Office of
Environment
& Heritage

Your reference: SSD 8392
Our reference: DOC18/313877
Contact: Miranda Kerr
Ph 02 6022 0607
Date: 15 June 2018

RE: Darlington Point Solar Farm (SSD 8392) – Exhibition of Environmental Impact Statement

ATTACHMENT A – OEH Assessment Summary for Darlington Point Solar Farm Environmental Impact Statement (SSD 8392)

Figure 1. Darlington Point Solar Farm (DPSF) project site with approximate position of transects

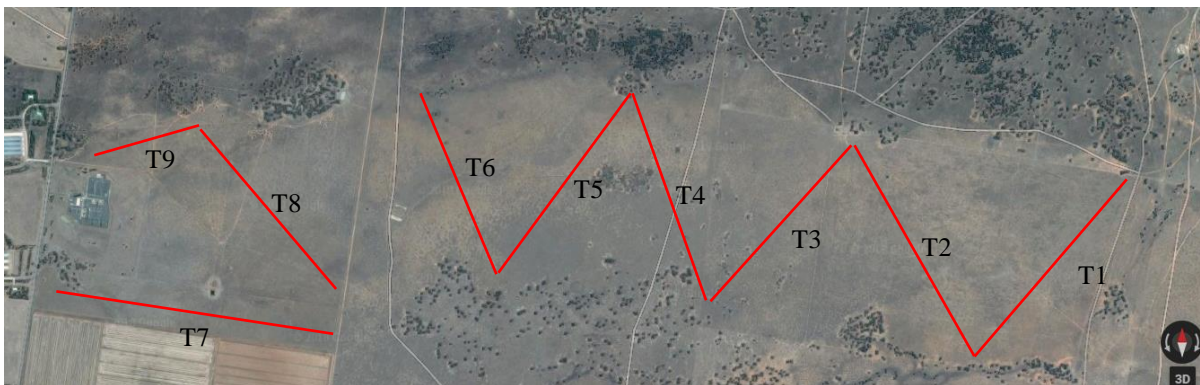
OEH have provided consistent advice, including at the site visit on 24 July 2017, email on 30 October, by phone on 10 November 2017 and on 19 March 2018 in response to the draft BAR, that the key issue for this site is the impact of the solar farm on biodiversity – the vegetation community, not just the dominant grasses, and that the assessment must address the impact of the solar farm on ecological functioning of the site's native vegetation.

The FBA allows the use of expert reports for determining species presence or absence on a site. To use an expert, the proponent must submit a request to OEH for approval by the OEH Chief Executive. An expert report is not considered unless this approval is given.

While the authors of the report have recognised expertise in agronomy, we have strongly recommended that the proponent consult expert grassland ecologists for advice on potential impacts and mitigation measures.

The proponent has not applied for, and the OEH Chief Executive has not granted, approval for the Charles Sturt University Graham Centre for Agricultural Innovation to provide expert advice for this project.

We have identified limitations of the study that would indicate that an agronomy-based approach is not appropriate for informing the project.

- The CSU report identified very few of the forbs that are listed in the Biobanking plots, which were sampled at a suboptimal time for species detection, and concentrated their assessment on native grasses. The impact of the proposal on overall species composition would then have been difficult to assess, and it seems that a general assumption has been made that if biomass is reduced through grazing and mowing, the native forb component is 'unlikely to be affected greatly'.

- The lower number of species reported by the CSU report indicates that the survey design for the CSU report may not be suitable for sampling the range of life forms present.

- The approach used for assessing credit discounts is based on the area in which the height of the dominant grass will be reduced by shading from the panels, which was calculated as 33% in the CSU report. That value was reduced to 20% through a suggestion, rather than evidence that the response of the grass would be curvilinear rather than linear. There is no basis in the CSU report for using growth reduction as a measure of impact, compared with other measures such as a reduction in species richness or change in cover of component species.

- *Experts providing reports for use in place of survey information in the BAR must be approved by the OEH Chief Executive.*
